Rezoning Transportation Analysis

Petition Number: 2020-122

General Location Identifier: Tax ID (02718124)

Revision Log:

RZ-1.0

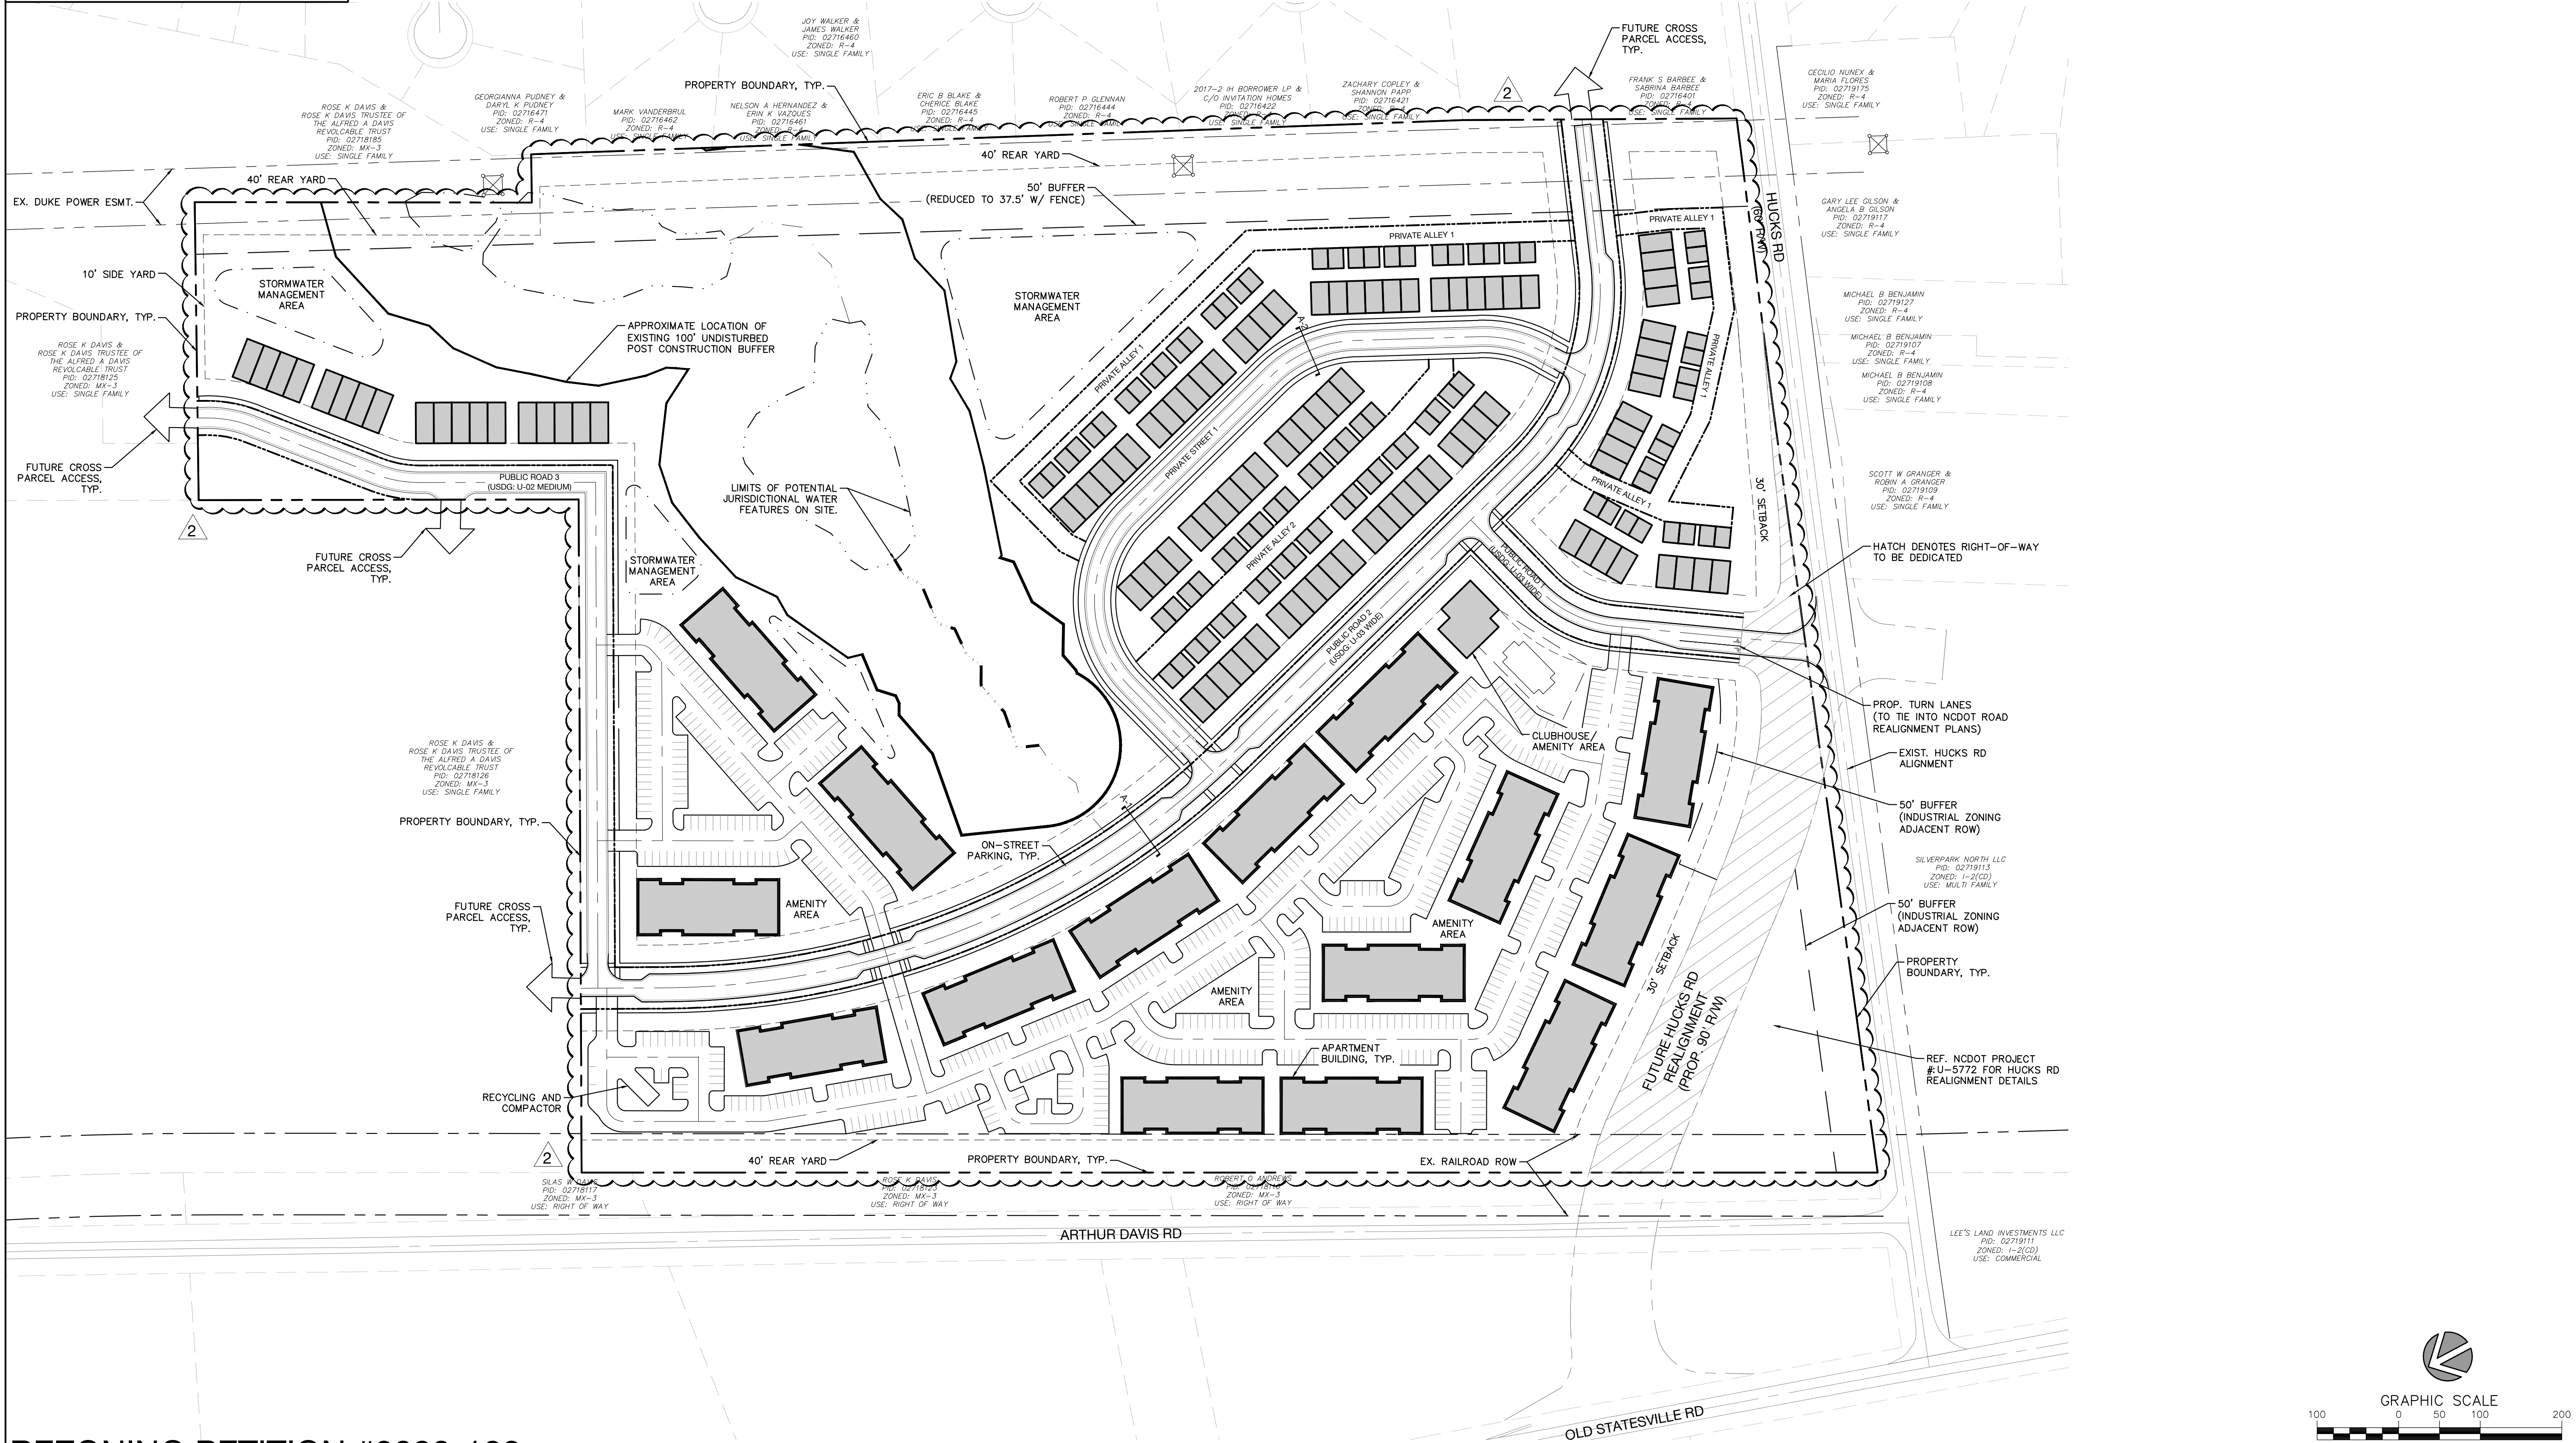
- Outstanding (site plan dated 10.12.20):** Revise the site plan and conditional note(s) to commit to construct the Hucks Road Realignment cross section as in the approved TIS scope. In lieu of a raised, curbed median island, install asphalt and a striped median instead. This will ensure that CFD can safely maneuver through the area. Construct the multi-use path as per CLDSM standards. **Dedicate public right-of-way and temporary construction easement limits, as included within the NCDOT STIP U-5772 25% design plans, sheets 12 and 20.**

3. ~~Outstanding (site plan dated 10.12.20):~~ Revise the site plan and conditional note(s) to commit to dedicate right-of-way for the Hucks Road Realignment, labeled and dimensioned for the total right-of-way dedication width.
4. **Outstanding (site plan dated 10.12.20):** Revise the site plan and conditional note(s) to commit to construct the portion of Hucks Road Realignment that is graphically depicted on the site plan sheet **RZ-1.0**, to match the approved TIS scope.
5. ~~Outstanding (site plan dated 10.12.20):~~ Revise the site plan and conditional note(s) to include the roadway improvements that are required within the final approved TIS.

9. **Outstanding (site plan dated 10.12.20):** Submit a [Right of way Abandonment Petition form](#) to CDOT for review of the potential abandonment of existing Hucks Road, with the commitment to construct the portion of Hucks Road Realignment, as shown on the site plan dated **7-10-2020**, dependent upon outcome of coordination with CDOT. The decision of this rezoning petition does not correlate with the decision of the possible abandonment, as this decision is issued within the separate Right-of-Way Abandonment process that is controlled by North Carolina General Statutes.
